From: [Wolfenbarger, Jeanne](#)
To: ["Jeff Wooten"](#); ["Kris Wiest"](#)
Cc: [Michel, Racquel M.](#)
Subject: SEC Gibson/University Cross Access Driveway/Chick-fil-A - TCL Resubmittals ((M15-D012C and M15-D012D)
Date: Friday, April 17, 2015 11:24:09 AM

SEC Gibson at University
Cross Access Driveway
Albuquerque, New Mexico

#### Pavement Sections

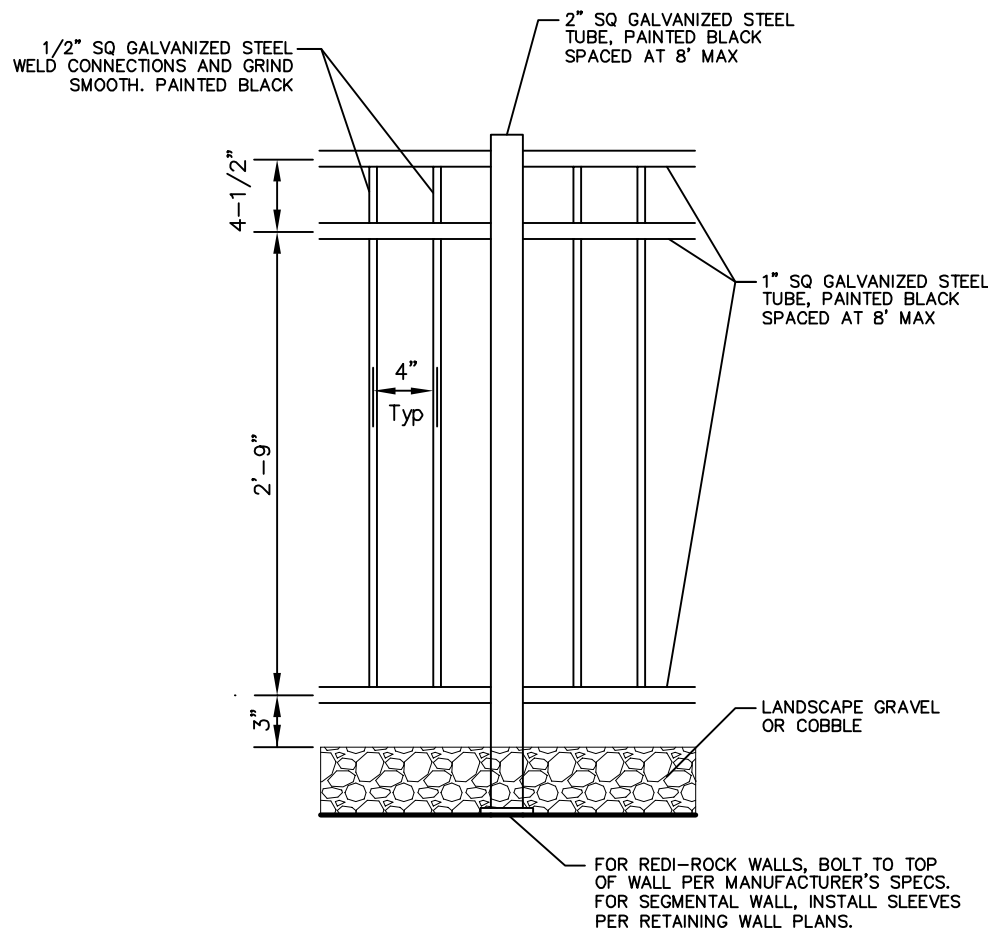
- The pavement section that you show is not an exact match for what is shown on the Merrick planset. (Your plan set calls for 12" subgrade, while the other plan set doesn't. The Merrick set calls out for a 1.5" lift and a 2.5" lift while your detail on Sheet C7 does not contain actual details of lift thicknesses.) This does not affect TCL approval as much as I just wanted to point this out to make sure there is not any confusion during construction with regard to exactly what pavement section to build for your access. If there are different pavement sections being used from one planset to the other, this ought to be reflected on each of the different plan sets.
